DRB Application No.: 04DRB-00656 (SBP)

Project Name JOURNAL CENTER

**CITY OF ALBUQUERQUE  
PLANNING DEPARTMENT  
Development Review Board  
May 5, 2004  
Comments**

**RE: Tract 1A-2-A-2, Journal Center**

SITE PLAN

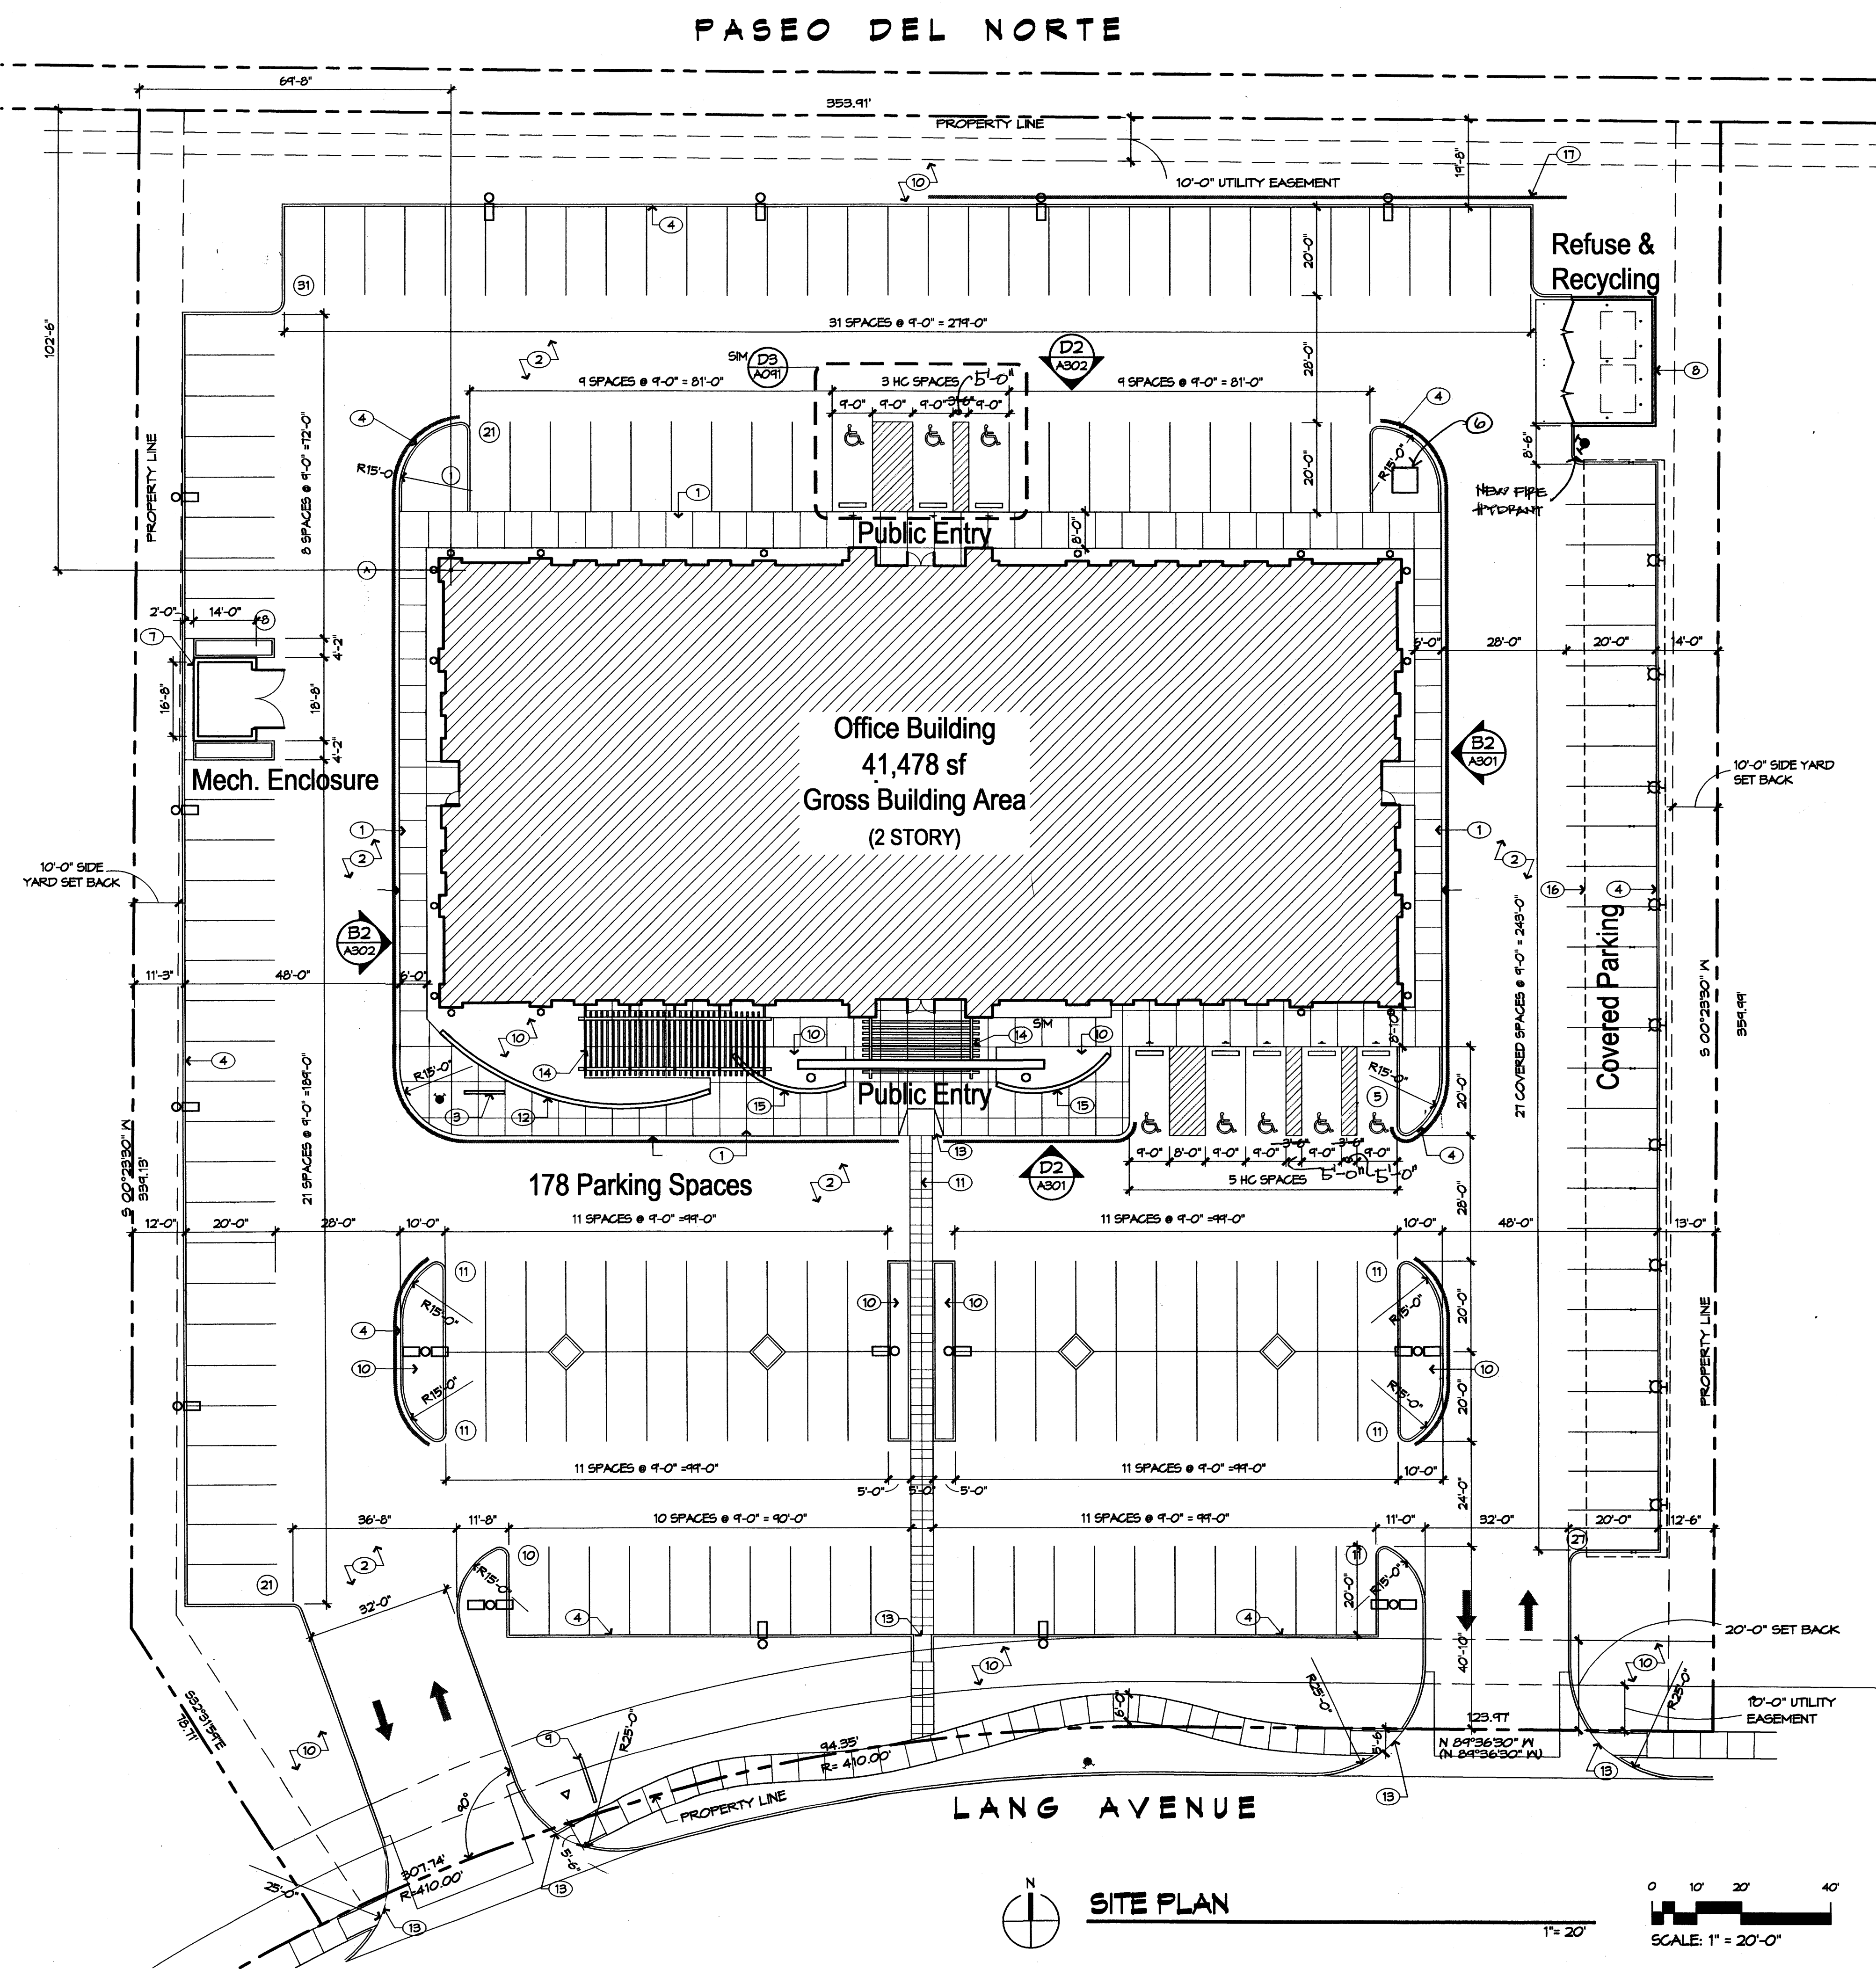
- CITY ENGINEER / AMAFCA: \_\_\_\_\_
- SIA
- Make sure that transformer is outside SD esmt
- sw esmt

DEKKER/PERICH/SABATINI ARCHITECTS agent(s) for RSF LAND & CATTLE CO., LLC request(s) this action for all or a portion of Tract(s) 1A-2-A-2, **JOURNAL CENTER**, zoned IP industrial park zone, located on LANG AVE NE, between JEFFERSON BLVD NE and HEADLINE BLVD. NE containing approximately 3 acre(s). [REF: 1000560, 04DRB-00089, 04DRB-00028] (D-17) **WITH THE SIGNING OF THE INFRASTRUCTURE LIST DATED 5/5/04 THE SITE DEVELOPMENT PLAN FOR BUILDING PERMIT WAS APPROVED WITH FINAL SIGN OFF DELEGATED TO CITY ENGINEER FOR SIA AND TO MAKE SURE TRANSFORMER IS OUTSIDE STORM DRAIN EASEMENT SIDEWALK EASEMENT.**

Please re-title the site plan sheet to read "Site Development Plan for Building Permit". Also, the new signature block should be used. It is available at the Front Counter of the One Stop Shop.

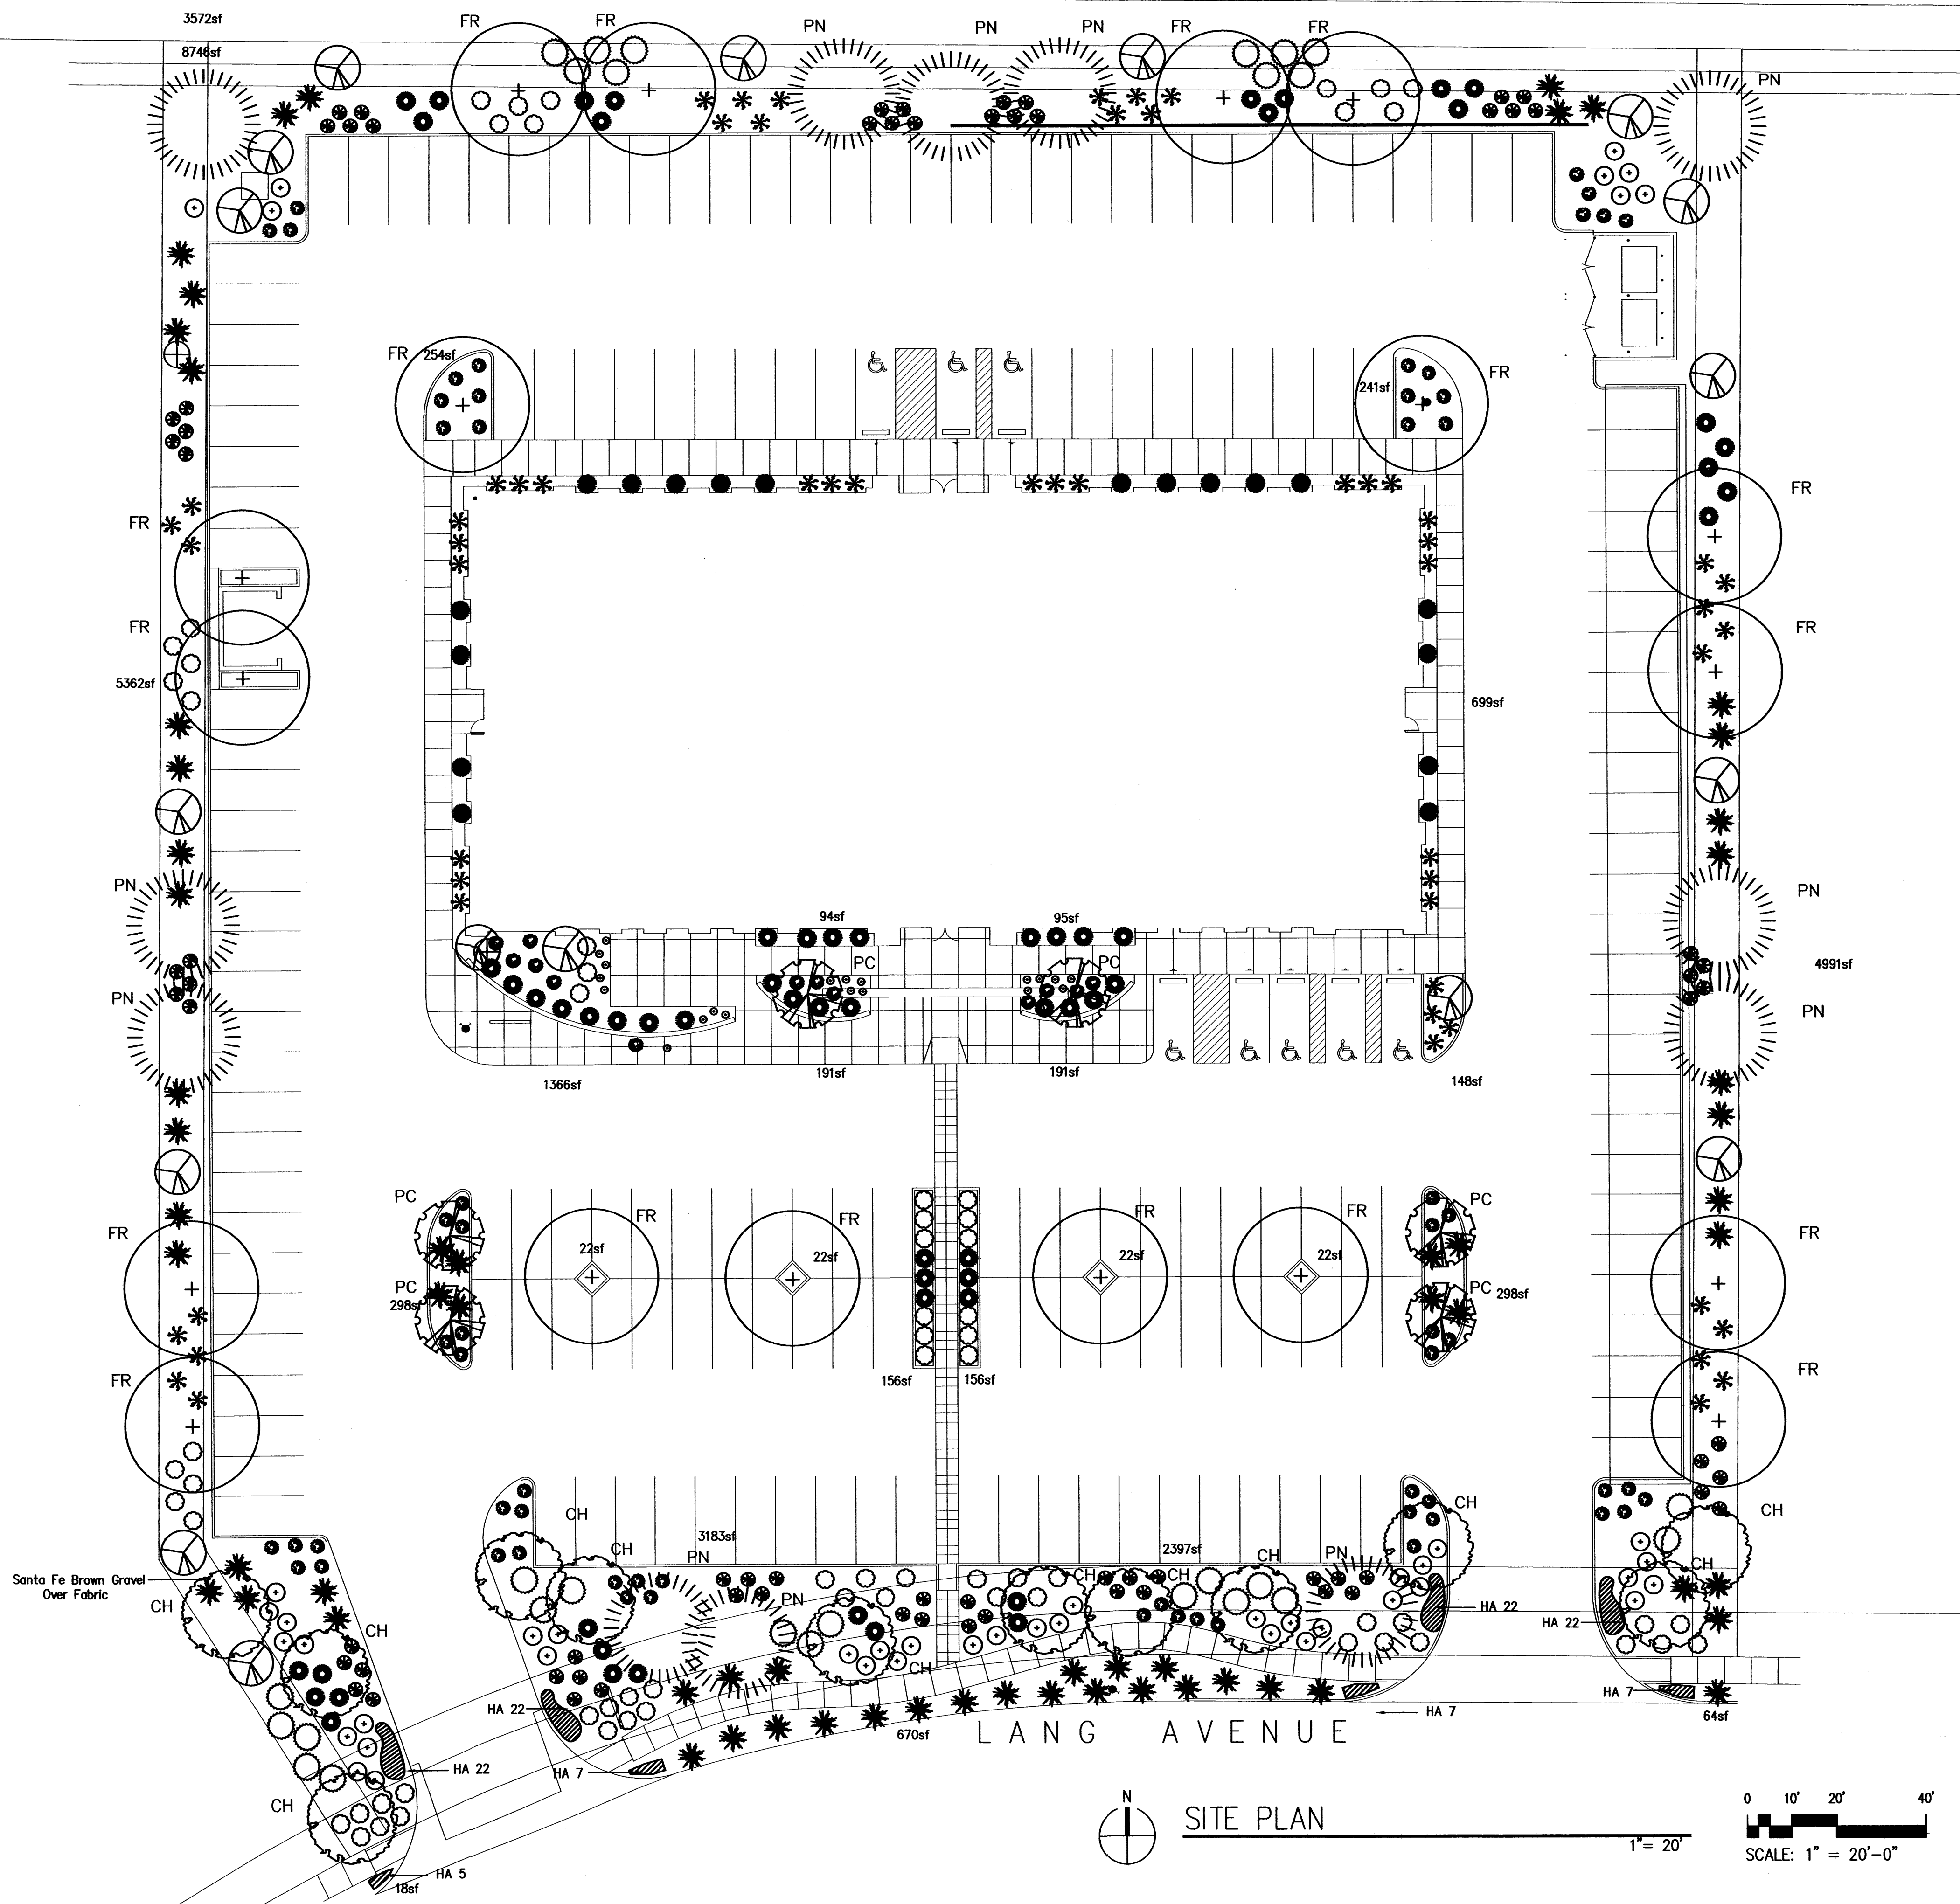
Landscaping Plan. Please provide a substitute for the junipers as they are a high allergen plant.

*Buffalo Junipers - female, low allergen*
